## **HINCKLEY NATIONAL RAIL FREIGHT INTERCHANGE**

### **The Hinckley National Rail Freight Interchange Development Consent Order**

### **Applicant's response to Deadline 7 Submissions [part 7 - Parish Councils]**

Document reference: 18.21

Figure 11.12: Night-time Views and Photomontages PVP 25

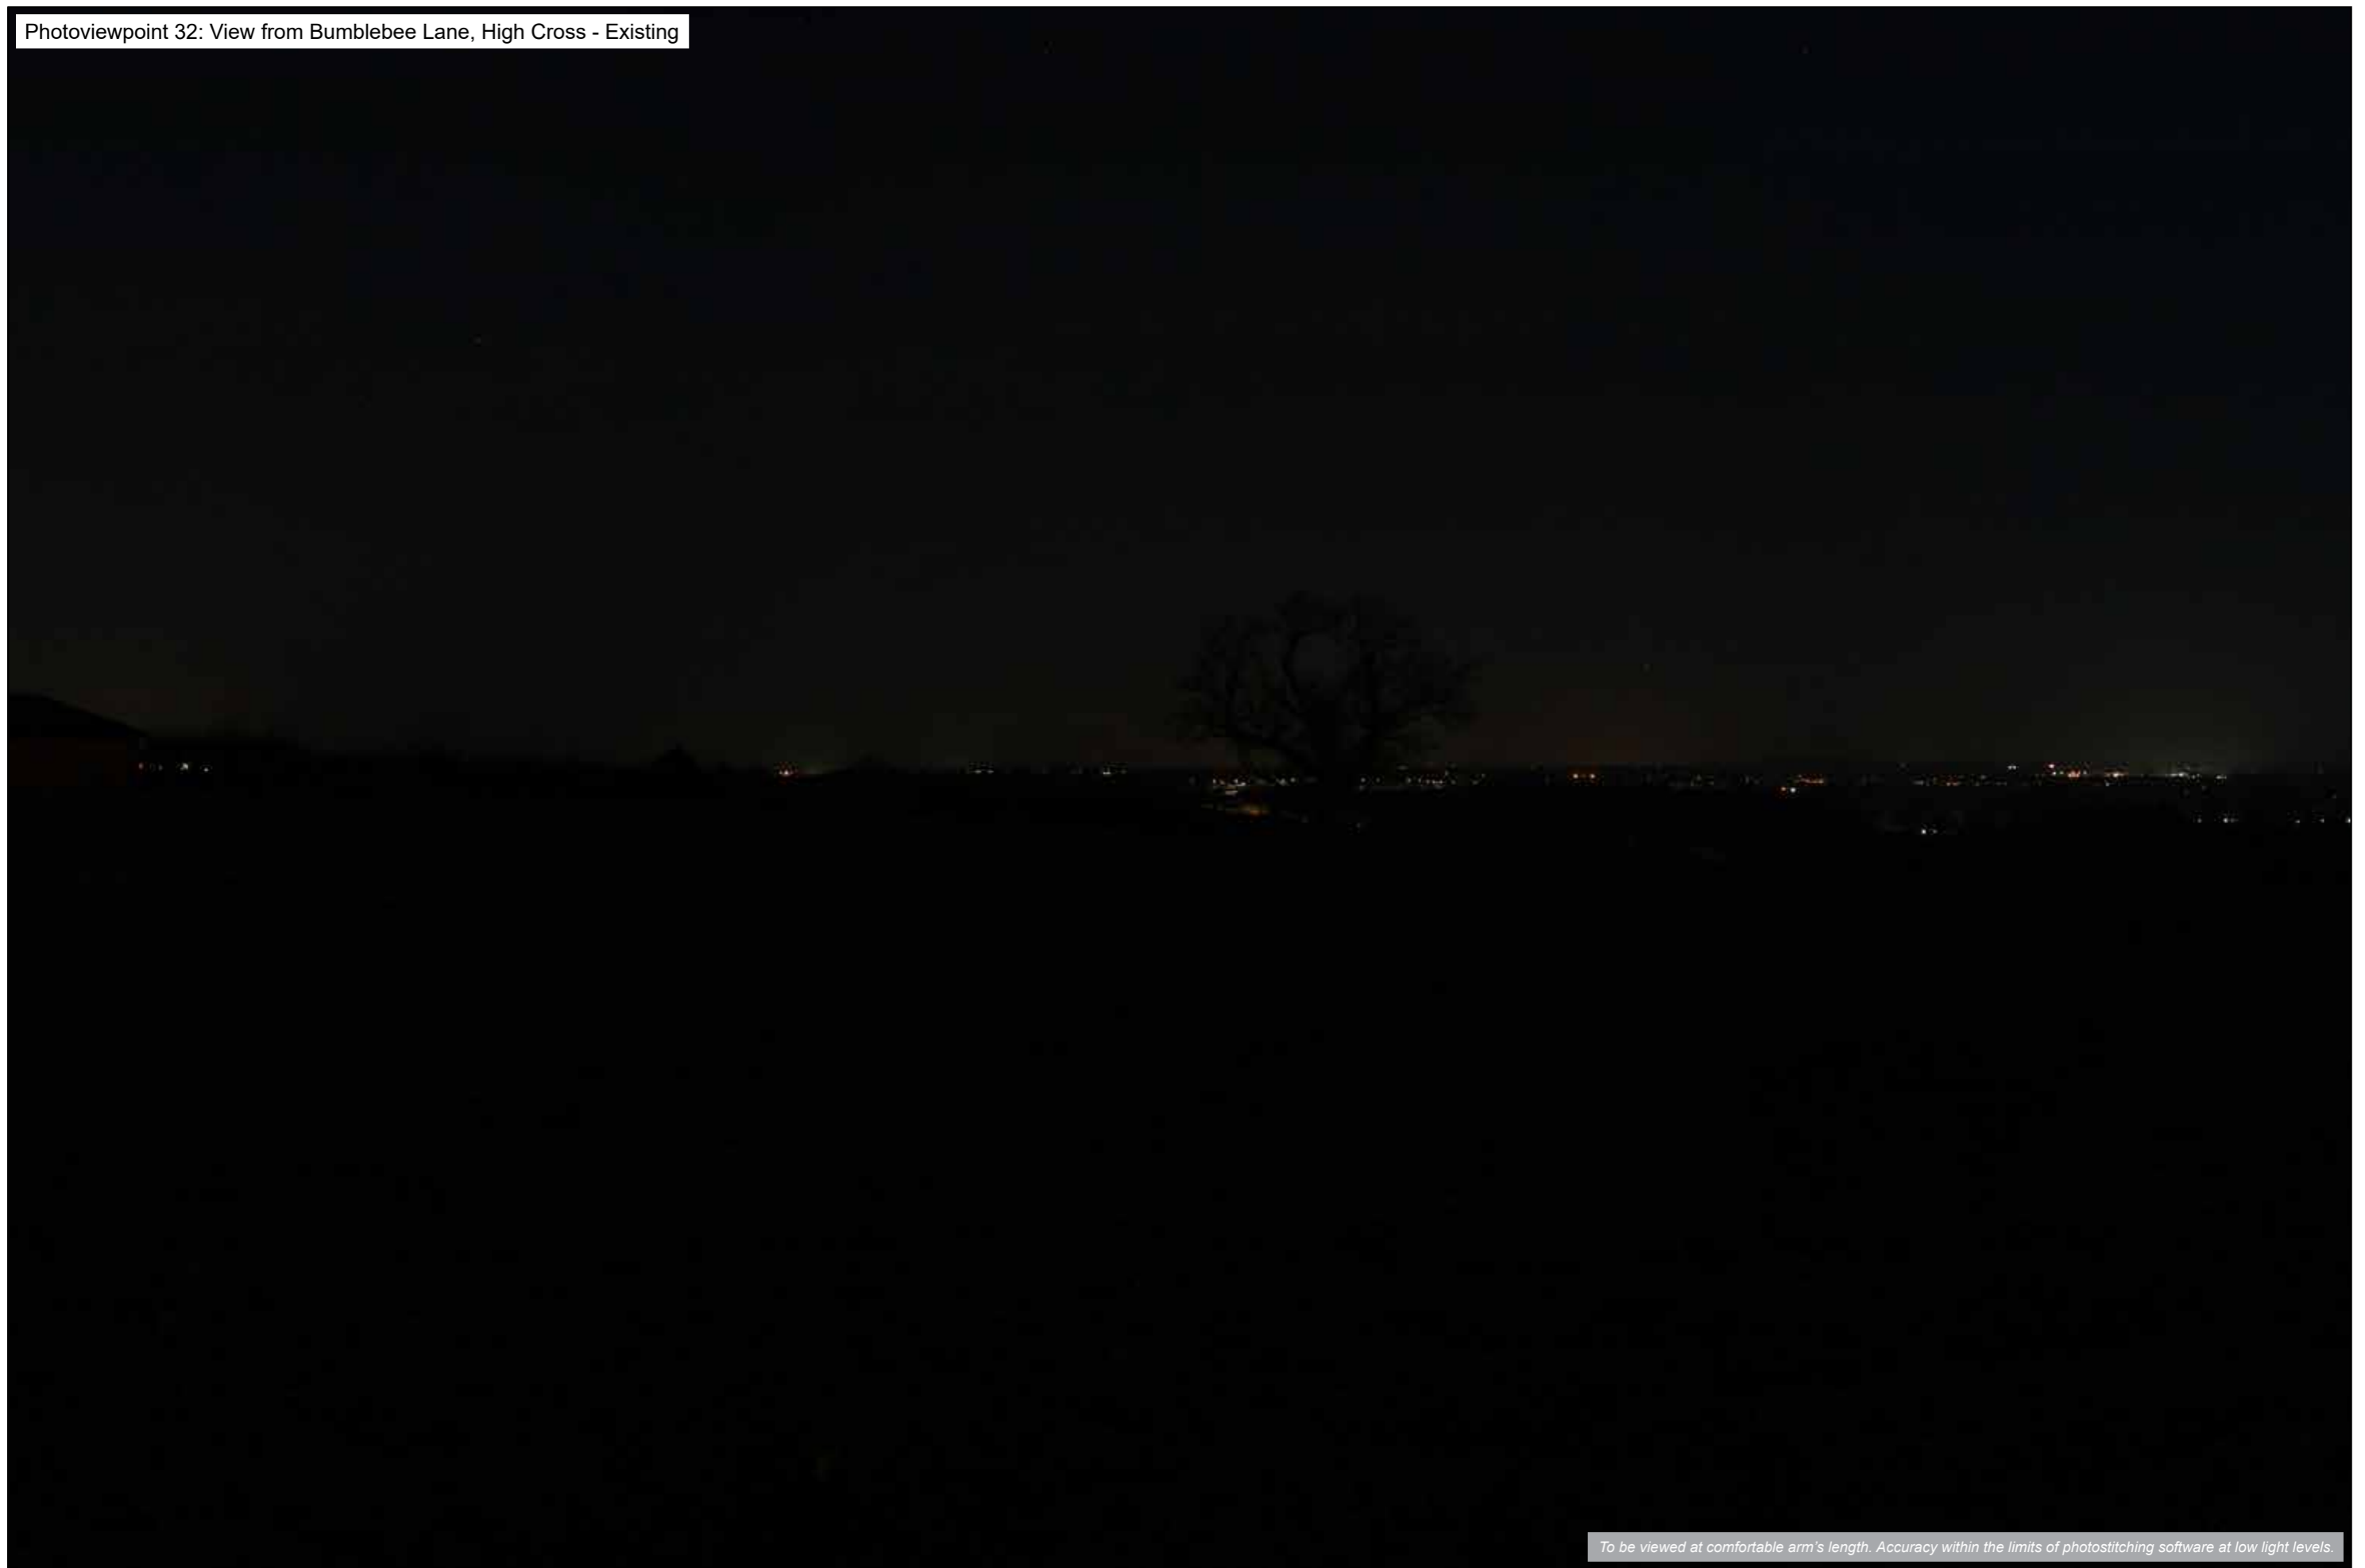
4.2	We question the choice of angles for viewpoints 18 and 48 and believe better angles could have been chosen by the applicant to provide genuine depictions of the current view and therefore meaningful comparisons. Nevertheless, we would be very interested to see photomontages of night-time views for viewpoints 18, 48, 49 and 50, but these don't appear to have been provided despite the proximity of the these viewpoints to both residential properties and the main HNRFI site.	The location of day-time and night-time views has been agreed with the local authorities and been the subject of statutory and non-statutory consultation. Location 18 and 48 demonstrate the lack of a clear view to the site from this direction. If a more open publicly accessible view had been available, it would have been used. Night-time views from Elmesthorpe are represented by Viewpoint 19 and this has been considered an appropriate approach by consultees.

FIG 2 - PROPOSED GATEWAY TREATMENT

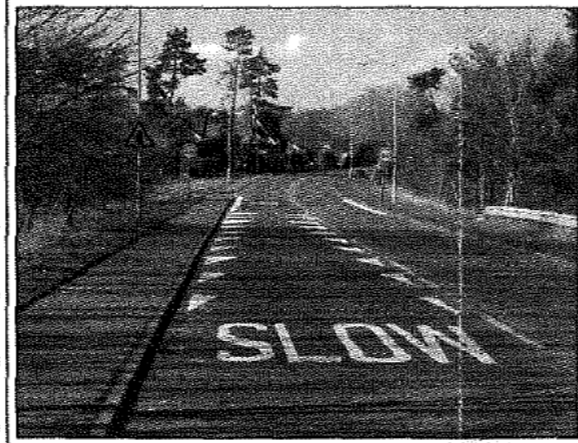
2.6.	<p>Enhancement Number 2: ...'Introduction of gateway feature to provide protection to cyclists rejoining carriageway.' There would absolutely need to be modelling done to investigate the effects of introducing a gateway feature here. Especially when considering the additional introduction of traffic signals as part of Enhancement 1. As previously discussed, traffic on and around this roundabout stands to increase with the introduction of the A47 Link Road, as a crucial part of the HNRFI route. Elements that could create potential delays and traffic queues on this roundabout need thorough assessment and modelling. There should also be attention drawn to the fact that there are notable amounts of parked cars on the carriageway of The Common and introducing a gateway feature could prove problematic for traffic travelling in both northerly and southerly directions.</p>	<p>As set out at point 2.5 modelling of the Common/A47 has been carried out. The enhancement is intended to benefit cyclists to encourage greater mode shift at the HNRFI site and beyond. Full safety audits and agreements with LCC will be carried out prior to its implementation.</p>
